WEST SUSSEX COUNTY COUNCIL CONSULTATION

TO:	Arun District Council FAO: Mrs A Gardner
FROM:	Highways, WSCC
DATE:	20/12/2018
LOCATION:	Progress Garage, Yapton Lane, Walberton, West Sussex, BN18 0AS
SUBJECT:	WA/106/18/DOC Approval of details reserved by condition imposed under ref WA/69/17/PL relating to Condition No 3,4,5,7,8,9.
DATE OF SITE VISIT:	
RECOMMENDATION:	☐ Advice ☐ Objection ☐ Modification ☐ No Objection ☒ More Information ☐ Refusal
S106 CONTRIBUTION TOTAL:	£N/A

DRAWING TITLE
Site Plan

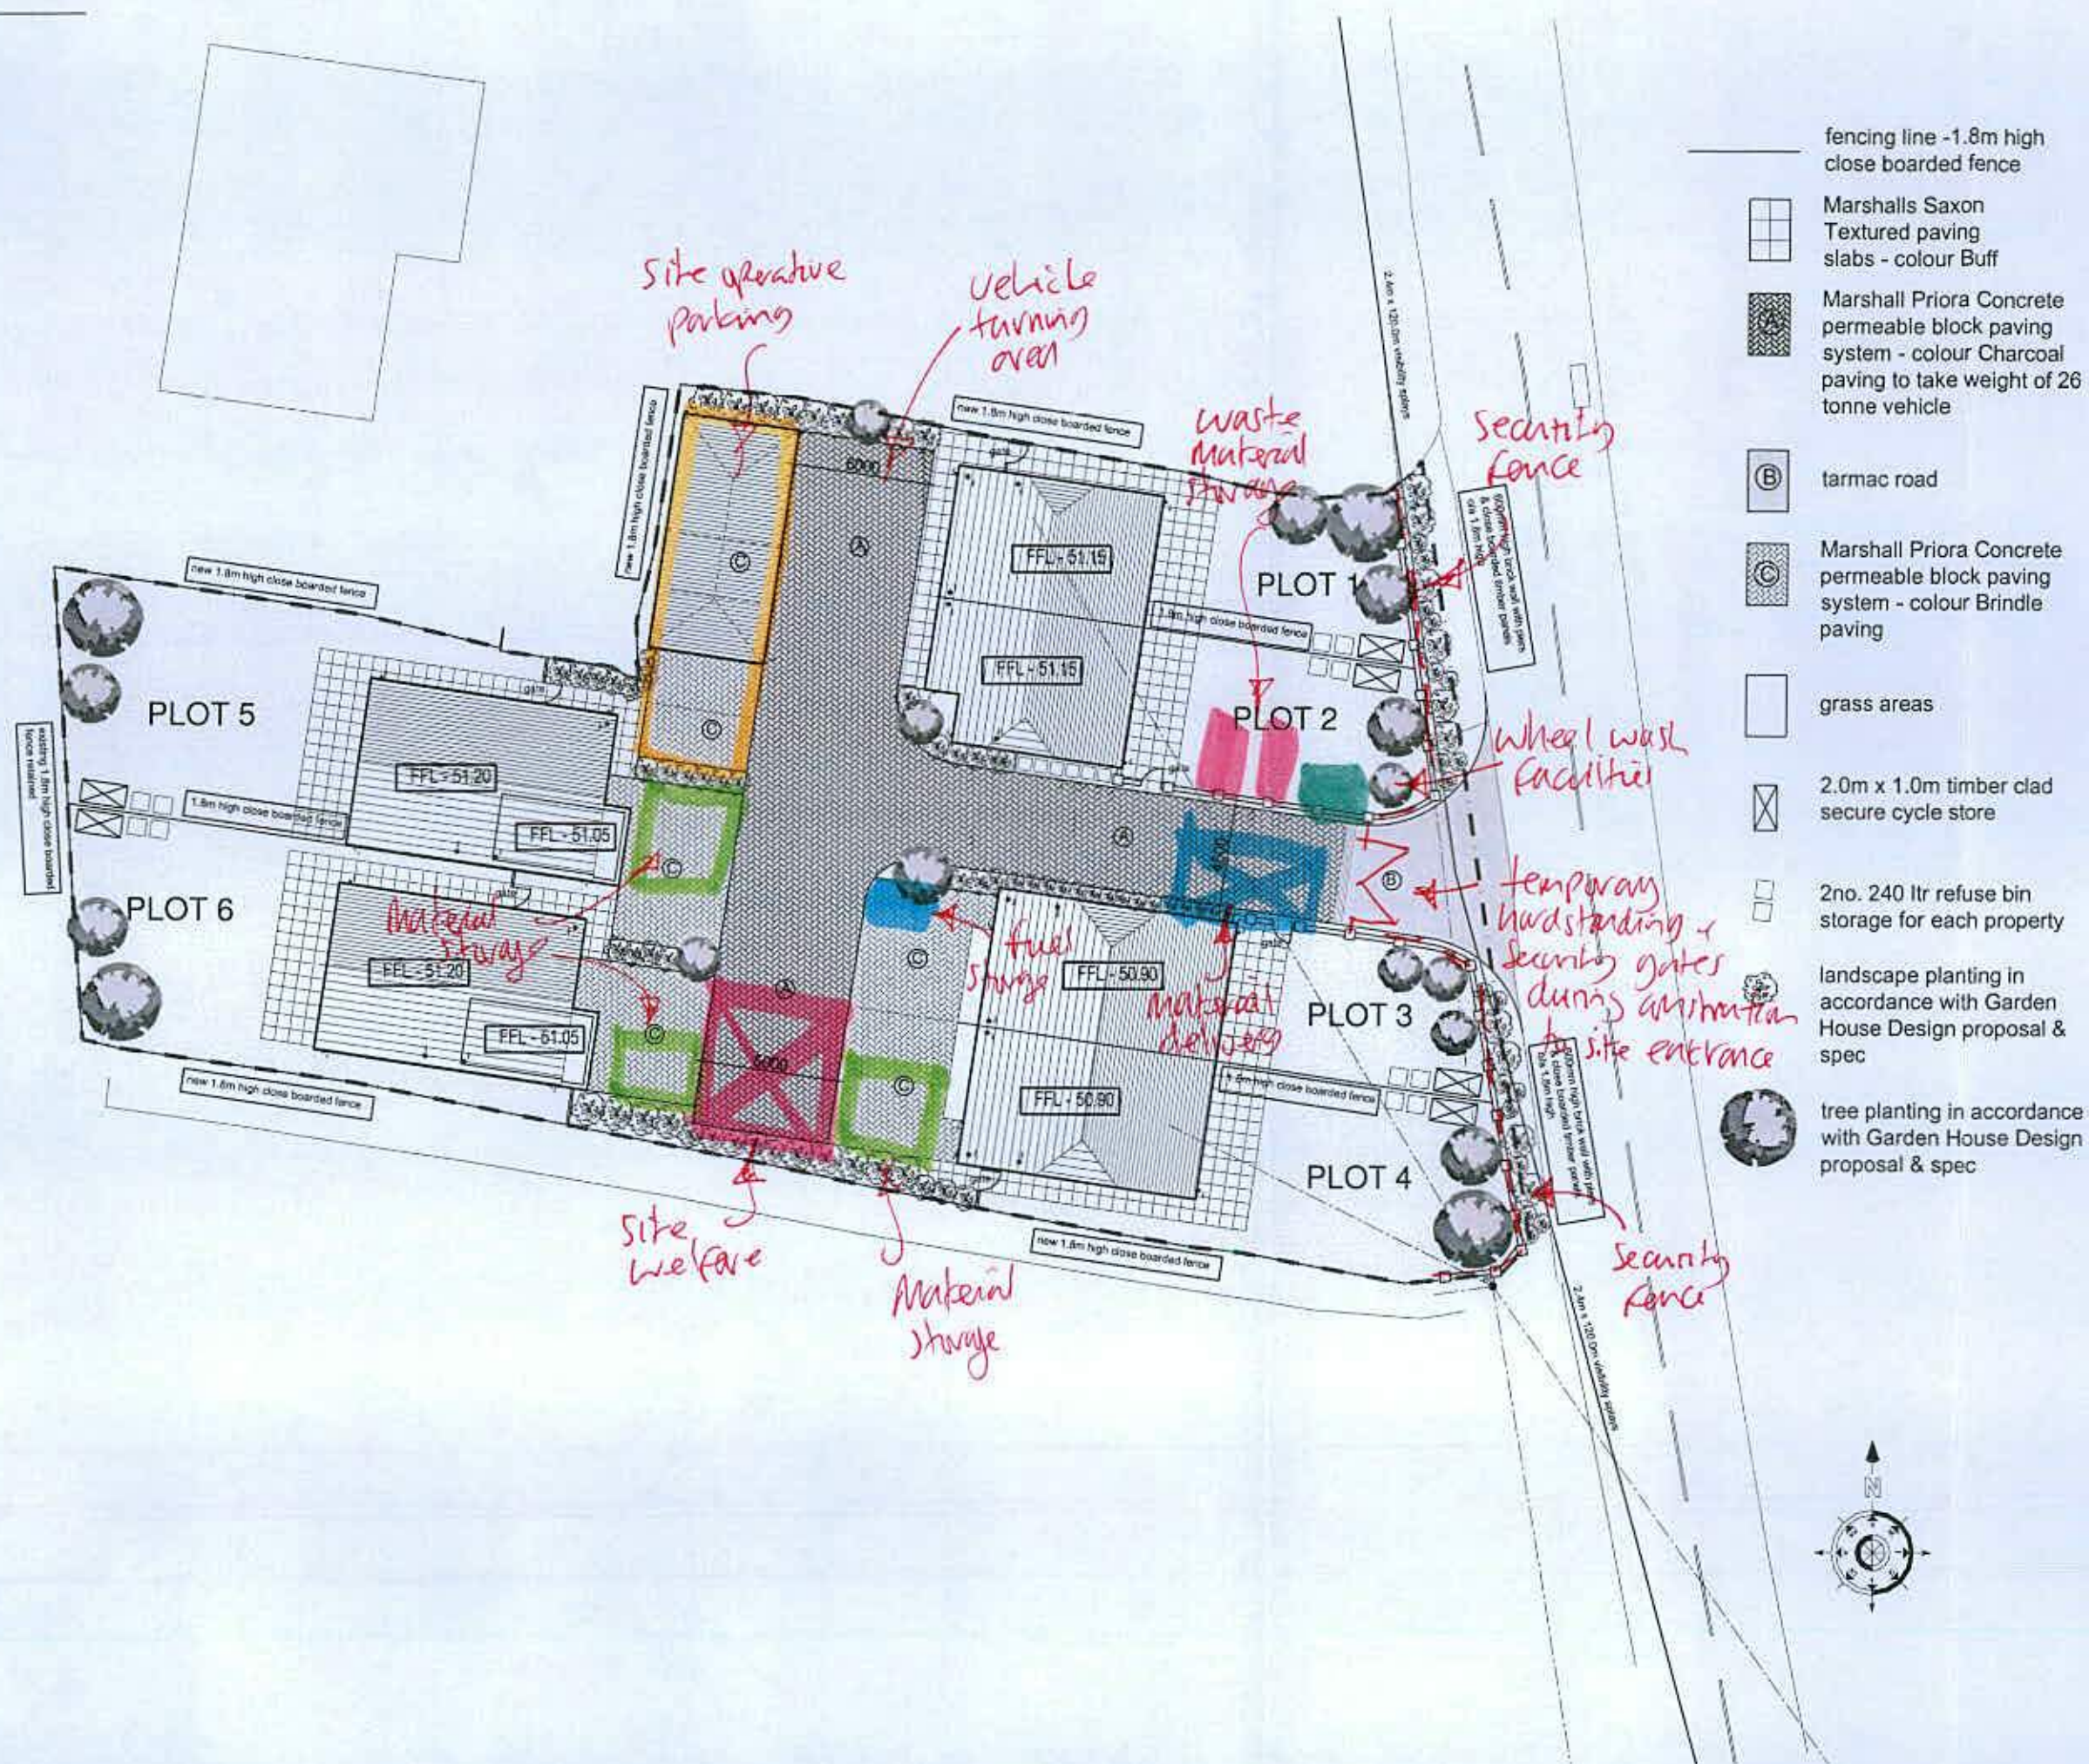
The Local Highways Authority (LHA) has observed the information provided and agrees with the majority of details set out by the CEMP and the site plan. However additional clarification is required to outline that a delivery vehicle could turn within the site to exit onto Yapton Lane in a forward gear. Although the applicant has stated that best efforts will be taken to ensure that smaller vehicles are used, the possibility that a larger HGV may enter the site is still a viable consideration. Although it is appreciated that a swept path was submitted at planning, this had not included details of the positioning of the welfare building within the roadway which restricts some of the space during construction.

Should this manoeuvre not be achievable- the applicant should ensure that a banksman is available within the site at all times to assist in the manoeuvring of vehicles onto the highway.

It is advised that deliveries are scheduled to be outside of the am and pm network peak times to avoid congestion on the highway.
